Response to Planning application from Hertfordshire County Council (T and CP GDP Order 2015)

District ref: 6/2020/1344/FULL
HCC ref: WA/2339/2020
HCC received: 23 June 2020
Area manager: Alan Story
Case officer: Vetti Vettivelu

BELL BAR PET FARM BELL LANE BROOKMANS PARK HATFIELD AL9 7AY

Change of use of amenity land to residential driveway with new dropped kerb to highway

Drawing Name
Existing Site Location Plan + Photos

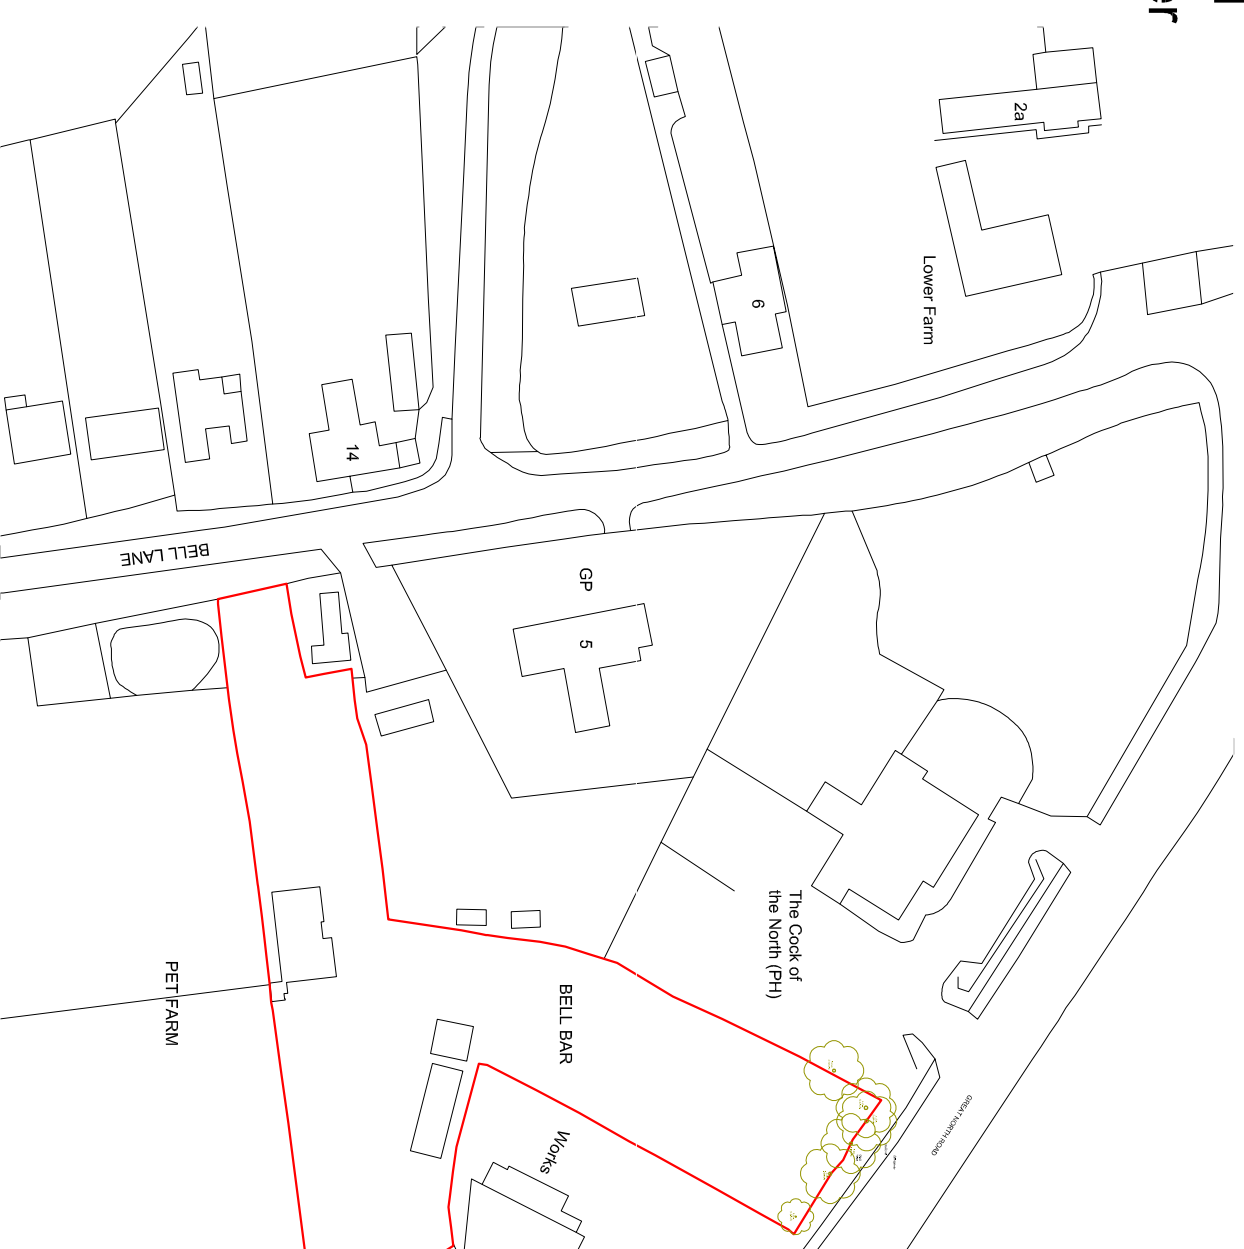
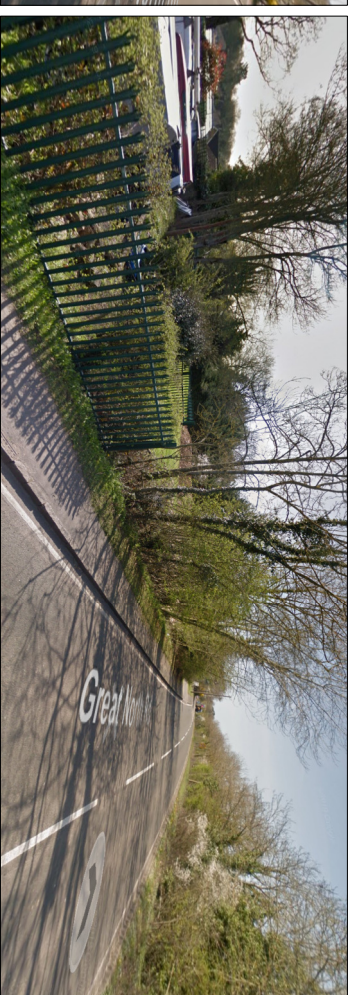
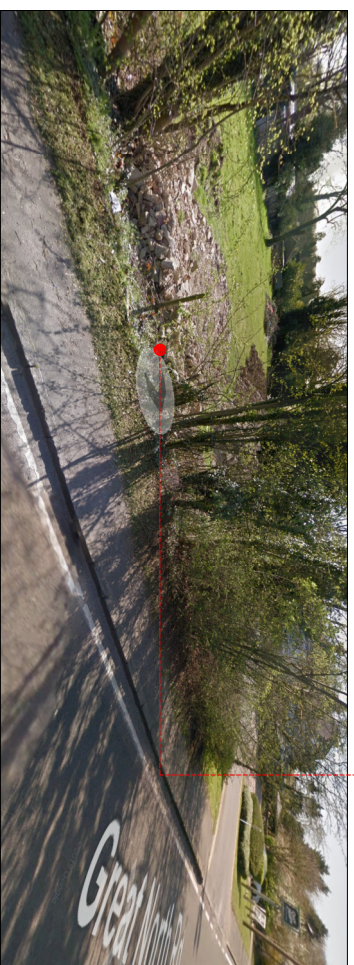
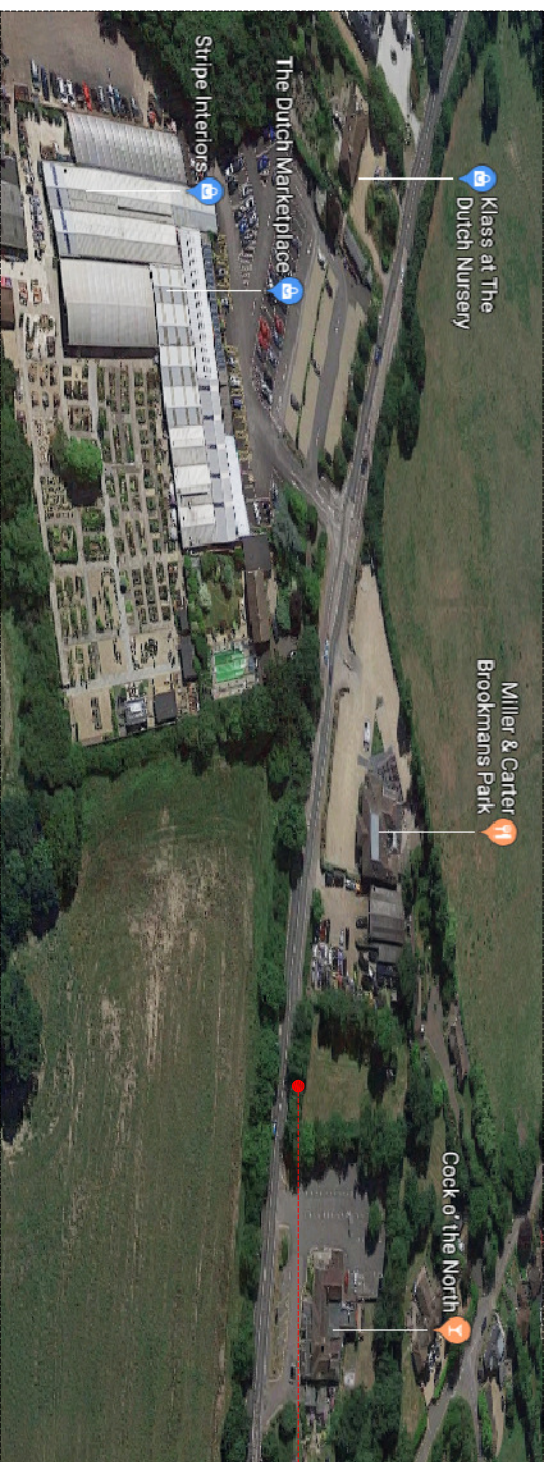
The proposal is a for a vehicle crossover from A1000 Great North Road an additional access/egress to the existing off Bell lane.

a. *Great North Road is a main distributor road. The access is in contrary to the Hertfordshire County Council's policies on Road hierarchy where the policy states, "Only consider new access onto primary and main distributor road where special circumstances can be demonstrated in favour of the proposal" and no special circumstances have been demonstrated.*

b. *Hertfordshire County Council's Guidance on Vehicle Cross overs state that if a property already has a dropped kerb, the Council will not normally approve a second dropped kerb unless there is sufficient space within the boundary of the property to drive a vehicle on and off the driveway in forward gear.*

Bell Lane where the existing access is an unclassified local access road and the suitable road to provide access to the above site and it is possible to enter and leave the site in forward gear.

In view of the above reasons the highway authority recommends that the application to be refused.
